RE: 78 Washington Avenue, BP# 2016-02202
CBL: 013 C005

Following an evaluation of your building permit application, this application fails to comply with the following sections of the 2009 international Building Code which is held in authority in the City of Portland Maine.

## Window installation in existing wall

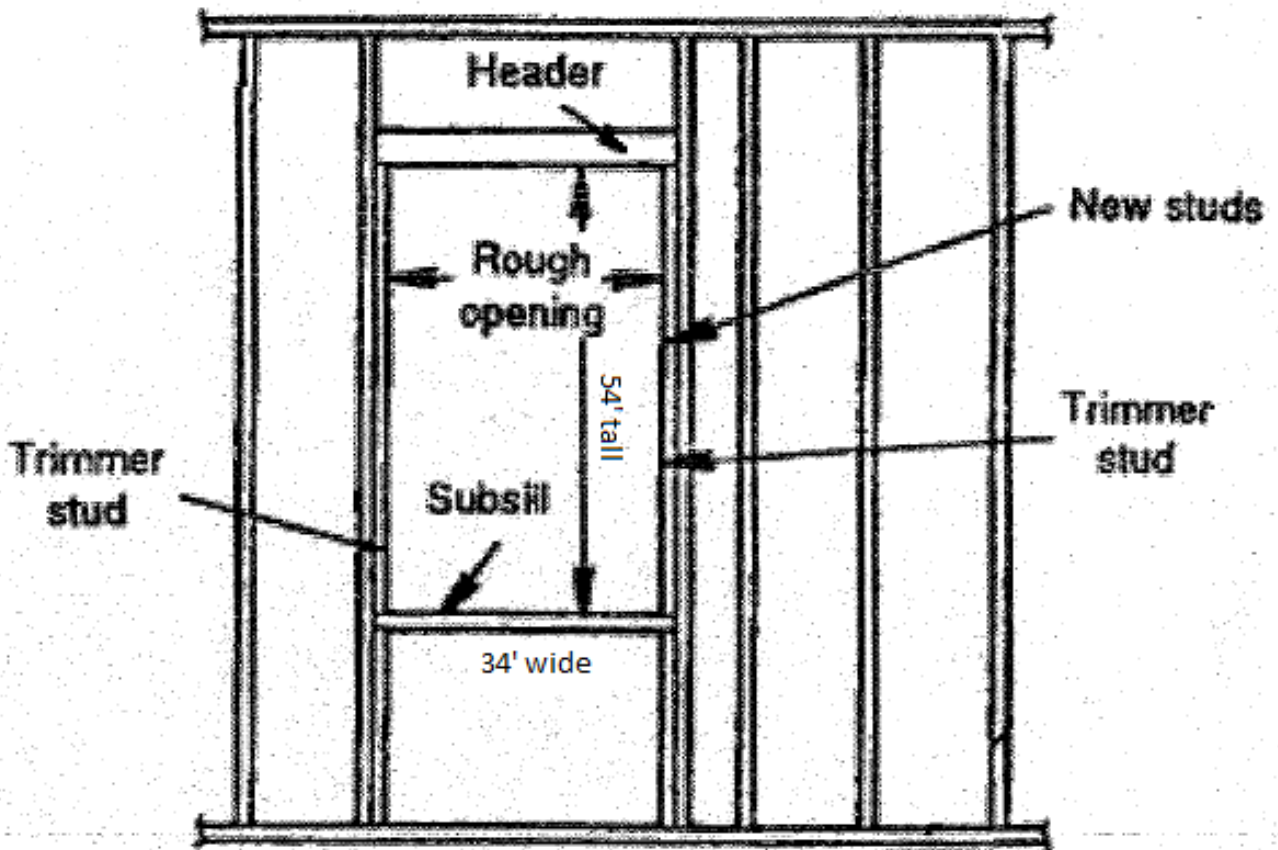
705.8.1 – The maximum area of unprotected and protected openings permitted in an exterior wall in any story of a building shall not exceed the percentages specified in table 705.8.

The neighboring properties building, adjacent to the wall in question, is less than 3 feet away.

Pursuant to section 105.3.1 of the International Building Code, this permit application is being denied. Per section 6-20 of the Portland Maine City Municipal Code, you are able to file an appeal with the board of appeals, within 10 days of receiving this letter, if you feel aggrieved by the outcome of this decision.
